KITTITAS COUNTY

MEMORANDUM

TO: All Staff
FROM: Public Works Plan Review Team
DATE: October 21, 2021
SUBJECT: BL-21-00023 Bach

The Public Works Department has reviewed the Request for Boundary Line Adjustment Application.

RECORD OF SURVEY
MIKE BACH
 NW 1/4, SE 1/4 SEC 35, T. 20 N., R. 17 E., W.M.
 ELK SPRINGS RD.
 PARCEL NO. 635436
 ELLENSBURG WA

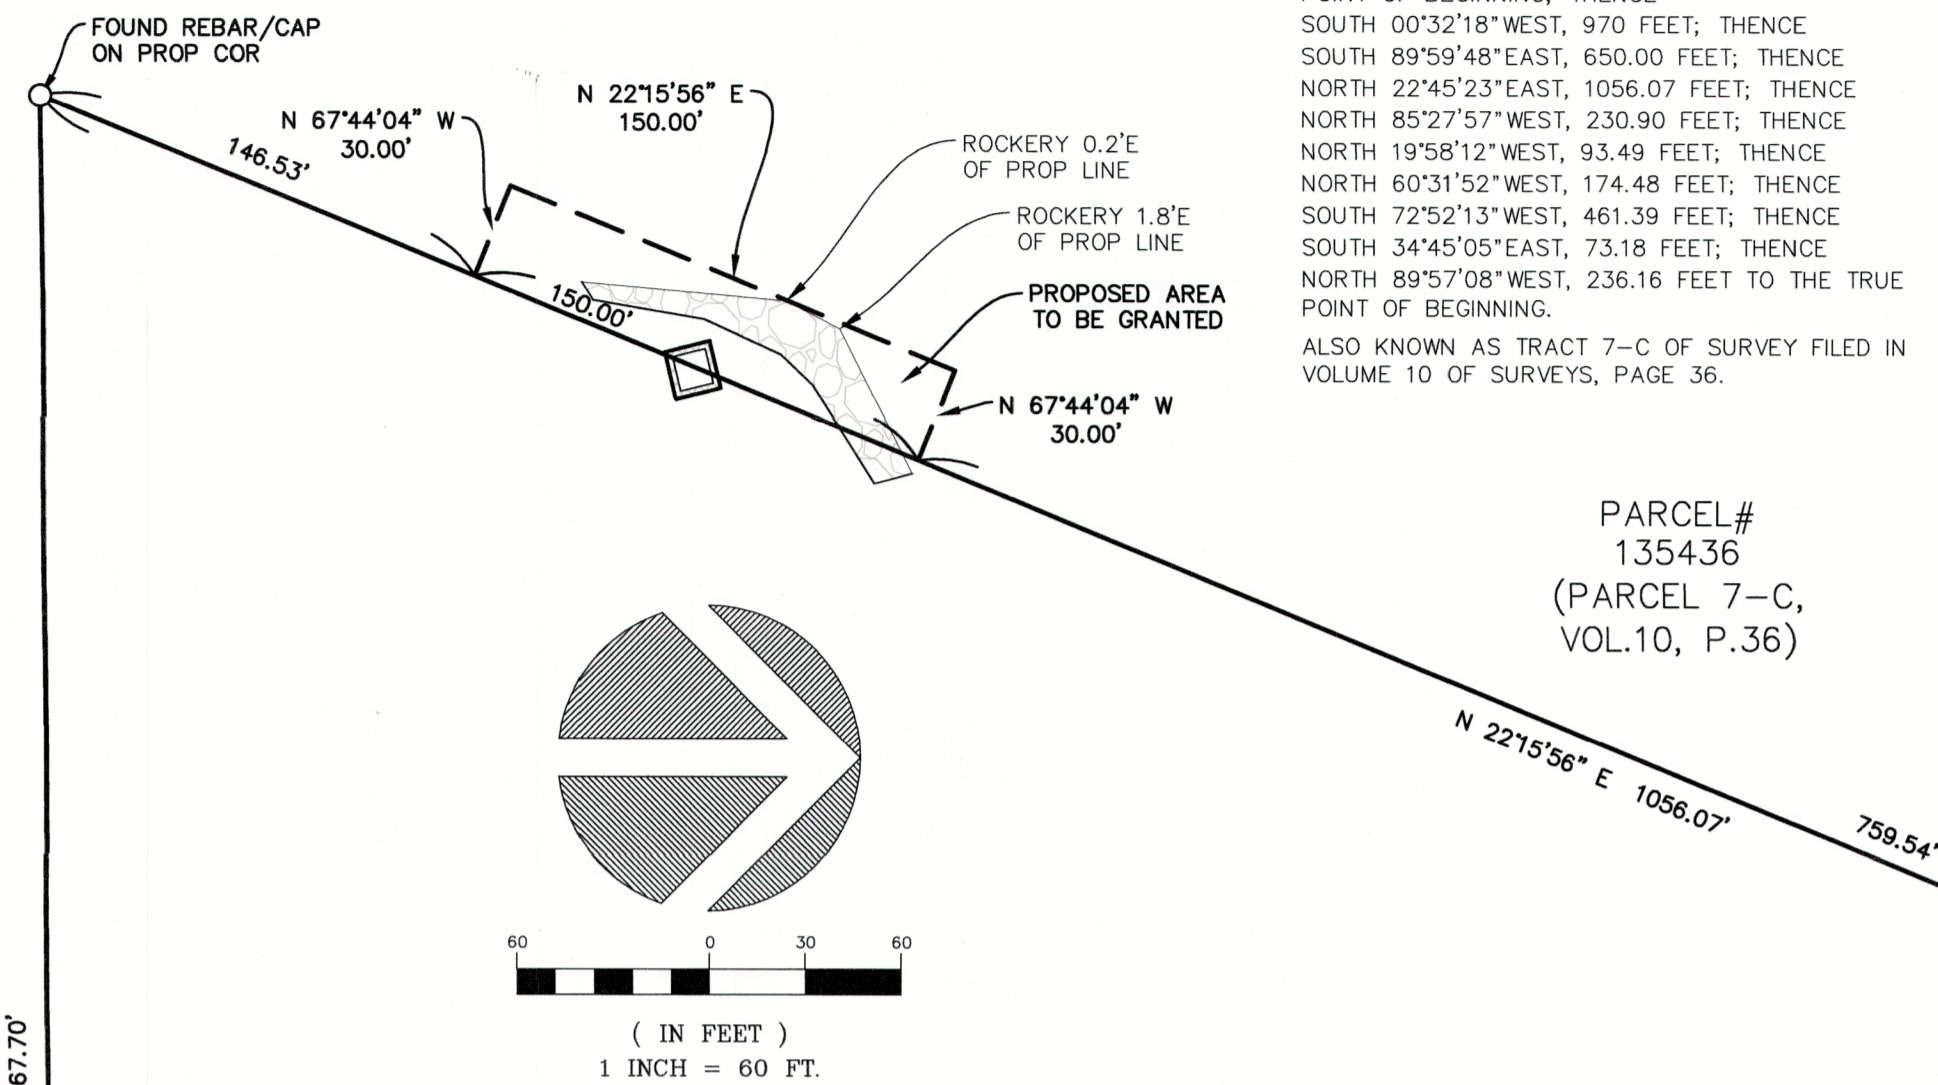
1. Records of Survey for Boundary line adjustments should show both parcels involved in the land transfer, as well as resultant areas for both parcels.
2. The entire new division line shall be staked in the field.
3. The proposed survey fails to adequately show controlling survey evidence. One corner is shown, and the other is shown as falling outside of the calculated position. Please shown what corners were utilized for the determination of property boundaries.
4. The Basis of bearing references a survey of record. The bearing referenced does not match this referenced survey.

5. There is a typo in the legal description of the Bach property at the last line (238.45 vs 288.45, both original and revised descriptions)
6. The "Adjoiner" legal description does not match the text of the title report of record.

7. The legal descriptions are a mixture of basis of bearings. The original descriptions match the survey of record, while the transfer parcel matches the prepared map. Correcting the basis of bearing issues would resolve this, but alternatively, the record bearings could be provided on the face of the map in brackets "(XXX.XX)" and referenced on the legend.

8. No legend shown.
9. The line "Thence S00°30'51"W, 864.69" within the Bach Legal description is missing from the title report. The title company can be informed, and generate an updated title OR, if they are unwilling to do so, the discrepancy can be noted and the source of the missing data (Survey:10-36) provided.

10. A note containing the purpose of the survey together with the application number.
(Example: The purpose of this survey is to show and describe new property boundaries in order to satisfy the requirements of Kittitas County Boundary Line Adjustment BL-21-00023)

11. The 'Box' located at the area to be adjusted should be identified (house?, shed?, barn?), and setback dimension shown.
12. Section, Township and Range should be shown in large text at the top of the page.
